Appeal Decision

Appeal Ref: APP/R5510/D/24/3339069

114 Northwood Road, Harefield, Hillingdon, UB9 6PS

- The appeal is made under section 78 of the Town and Country Planning Act 1990 against a refusal to grant planning permission.
- The appeal is made by Mr Liam Halpin against the decision of the Council of the London Borough of Hillingdon.
- The application Ref 20106/APP/2023/3090, dated 24 October 2023, was refused by notice dated 8 January 2024.
- The development proposed is extension to existing loft conversion to include hip to gable conversion – installation of rear dormer and two number front roof light windows and front porch.

PROPOSED REAR ELEVATION
SCALE BAR 1:50 @ A1

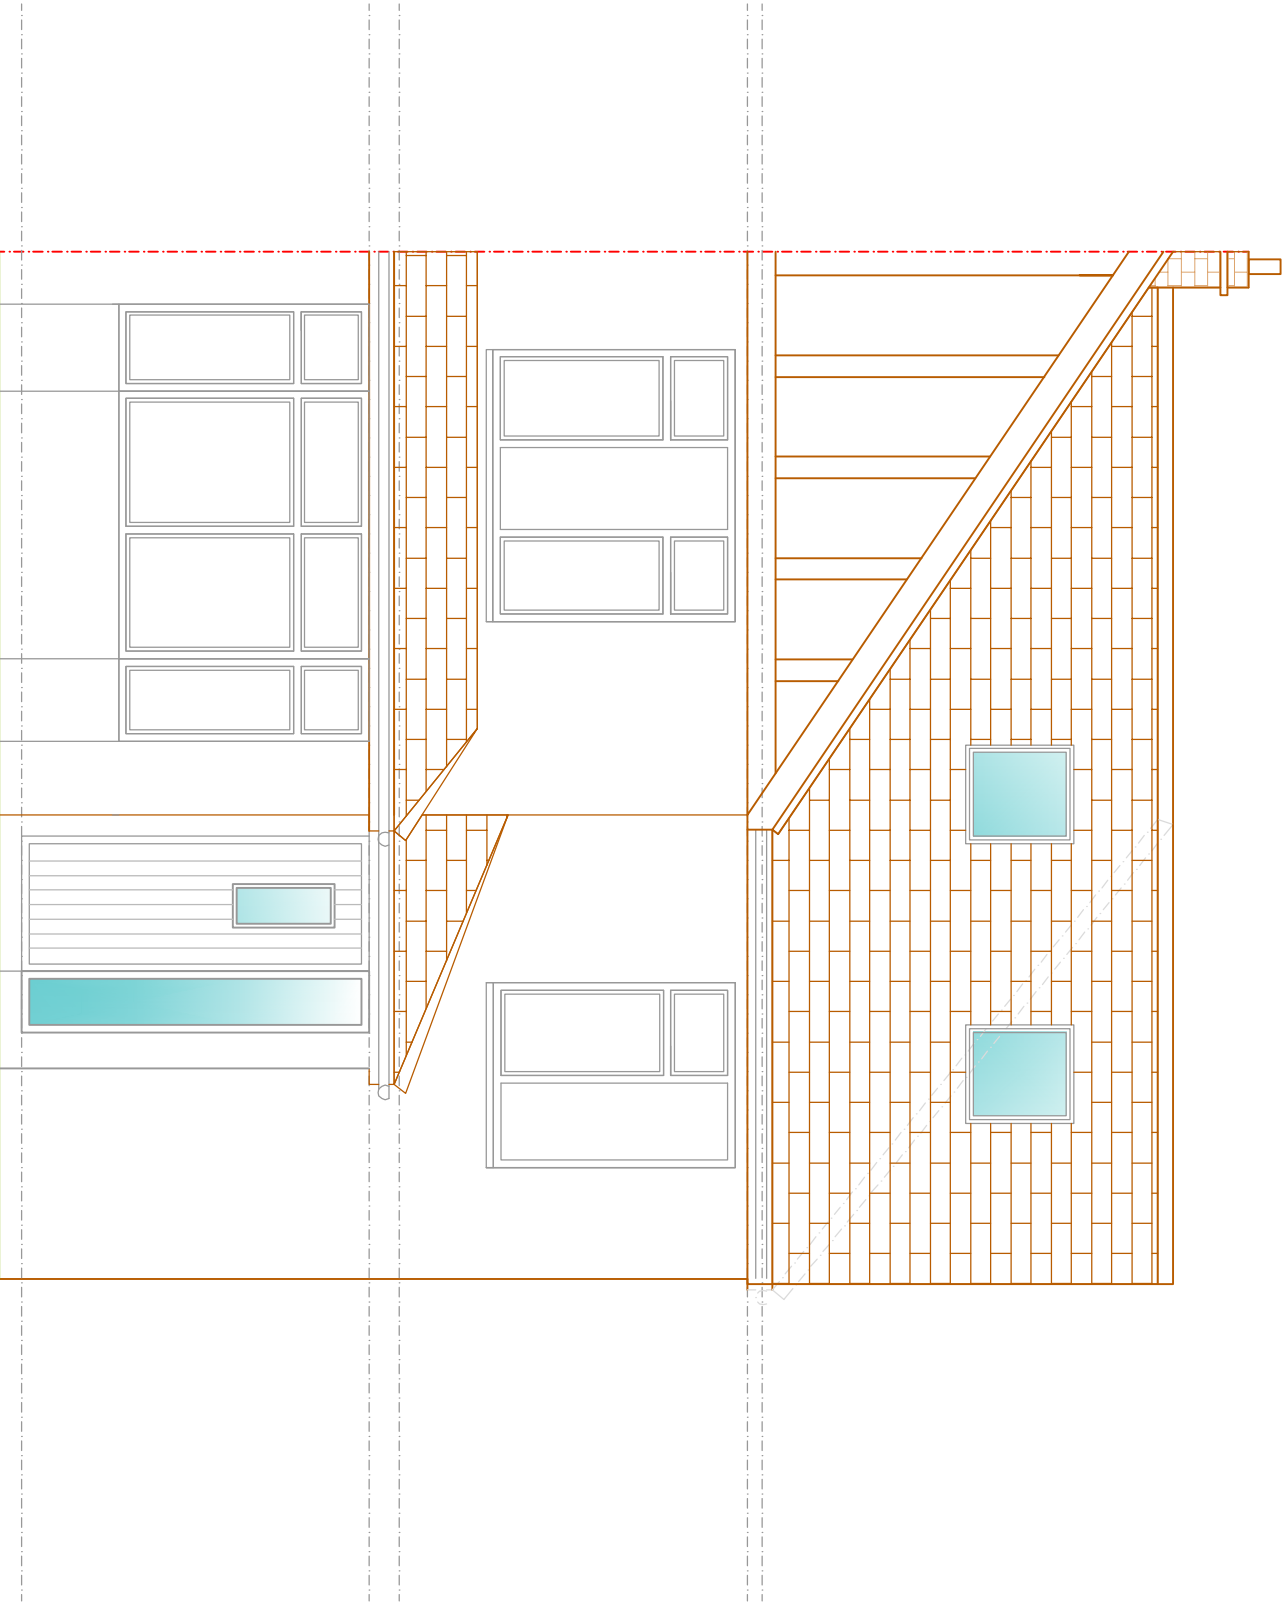
5. The proposed extension to the roof space would result in a new gable element replacing the existing hipped roof. It would be over that part of the building which is set back from the main front gable which is shared with the adjoining semi-detached house, No. 116, and which dominates the combined frontage of the building as a whole. Although it would alter the existing composition and symmetry of the building, I consider that it would integrate with the appearance of the building. It would not result in a disproportionate increase in bulk and its scale would be in keeping with the varied house styles along the street. There would be no increase in height above that of the main ridge.

6. I consider that the design of the hip to gable roof is appropriate in the context of the general character of the surrounding area. It would be set back from the main front gable and would not result in an over-large extension. There would be no adverse cumulative effect on the character and appearance of the street scene where there is a variety of roof forms, including a similar example further along the street to the east.

7. The proposed rear dormer, although out of proportion with the existing roof, would be set away from the ridge, eaves and sides of the new roof and in proportion with it. It would exceed two thirds of the width of the original roof but the window glazing would be aligned with that of the first floor windows below. Although overall the dormer would be larger than the guidance in policy DMHD1, it would not be readily visible from public viewpoints and this element alone would not be sufficient to justify dismissing the appeal.
